**RE: Cool Springz Trampoline Park (Tract C-1)**  
**Conceptual Grading Plan**  
**Stamp Date: no stamp**  
**Hydrology File: F17D095B**

Based upon the information provided in your submittal received 4/13/2017, the Conceptual Grading Plan **is not** approved for Building Permit, Site Plan for Subdivision, and Site Plan for Building Permit. The following comments need to be addressed for approval of the above referenced project:

Erosion Sediment Control Plan

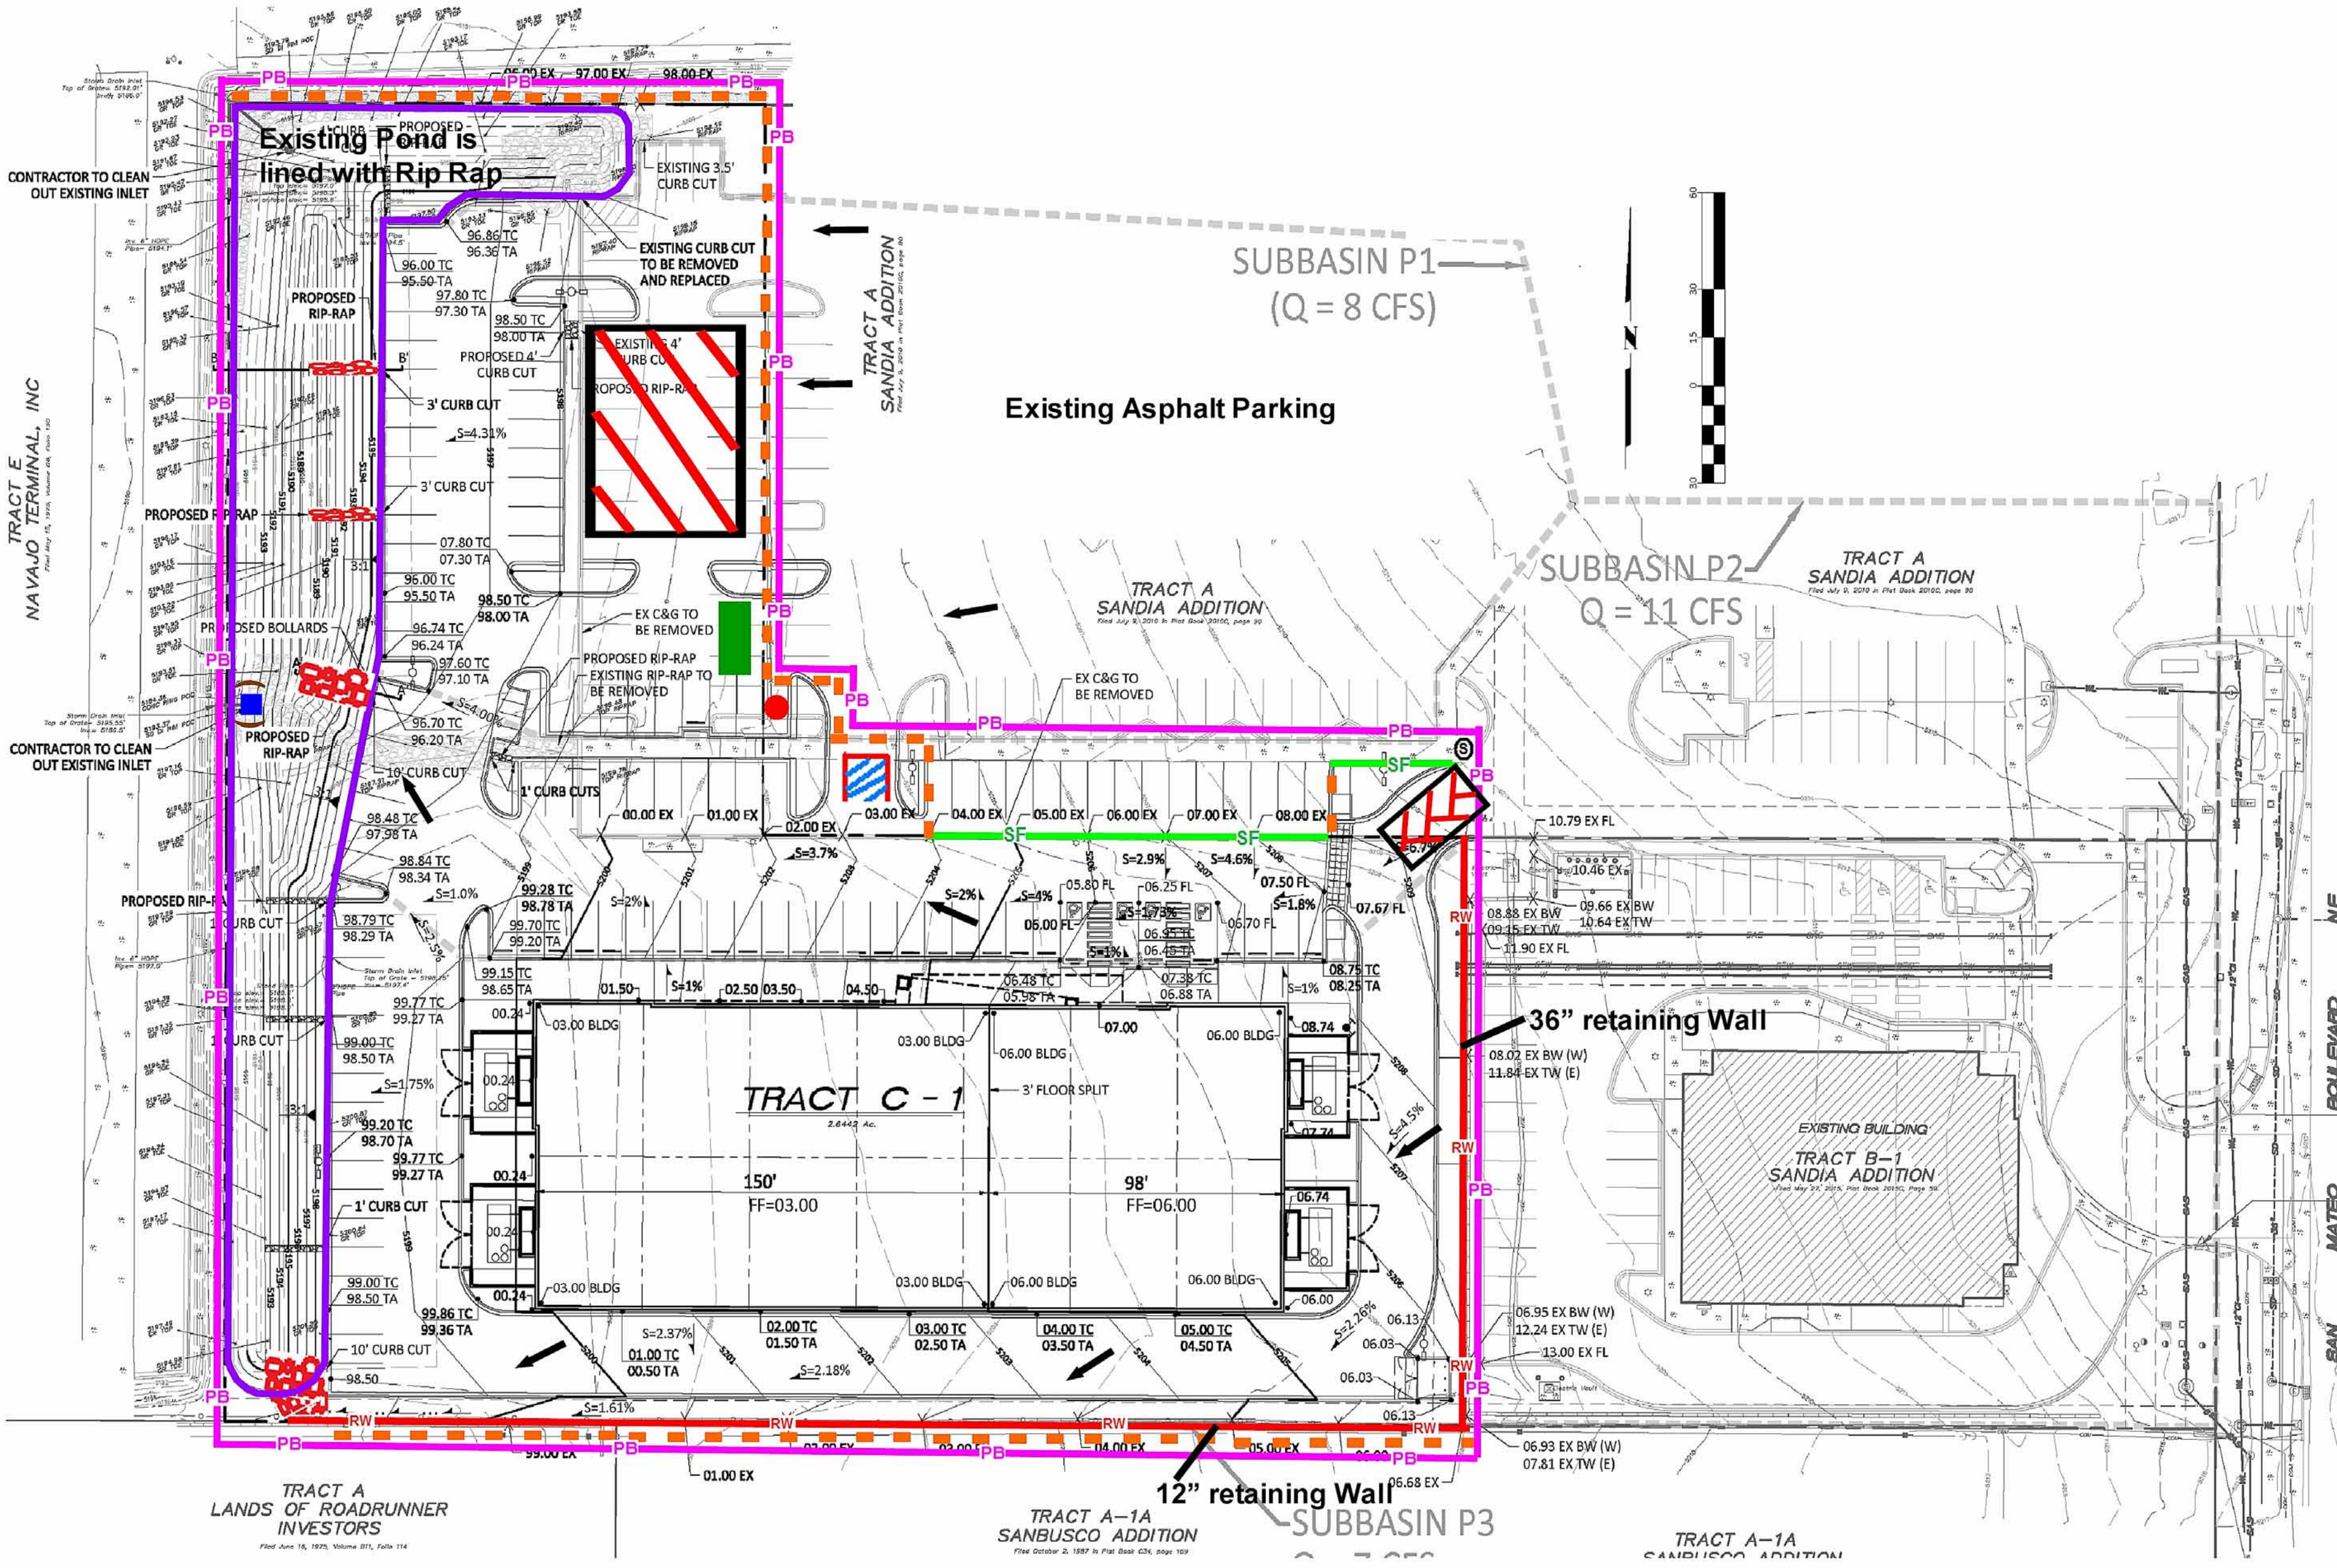
2. There is also not stamp and signature on the Grading Plan. Please provide them.
3. More than 1 acre of disturbance is proposed, therefore an Erosion and Sediment Control Plan is required and is to be submitted to the storm water quality engineer (Curtis Cherne, PE, [ccherne@cabq.gov](mailto:ccherne@cabq.gov)). An approval for this must be given prior to Hydrology's approval.
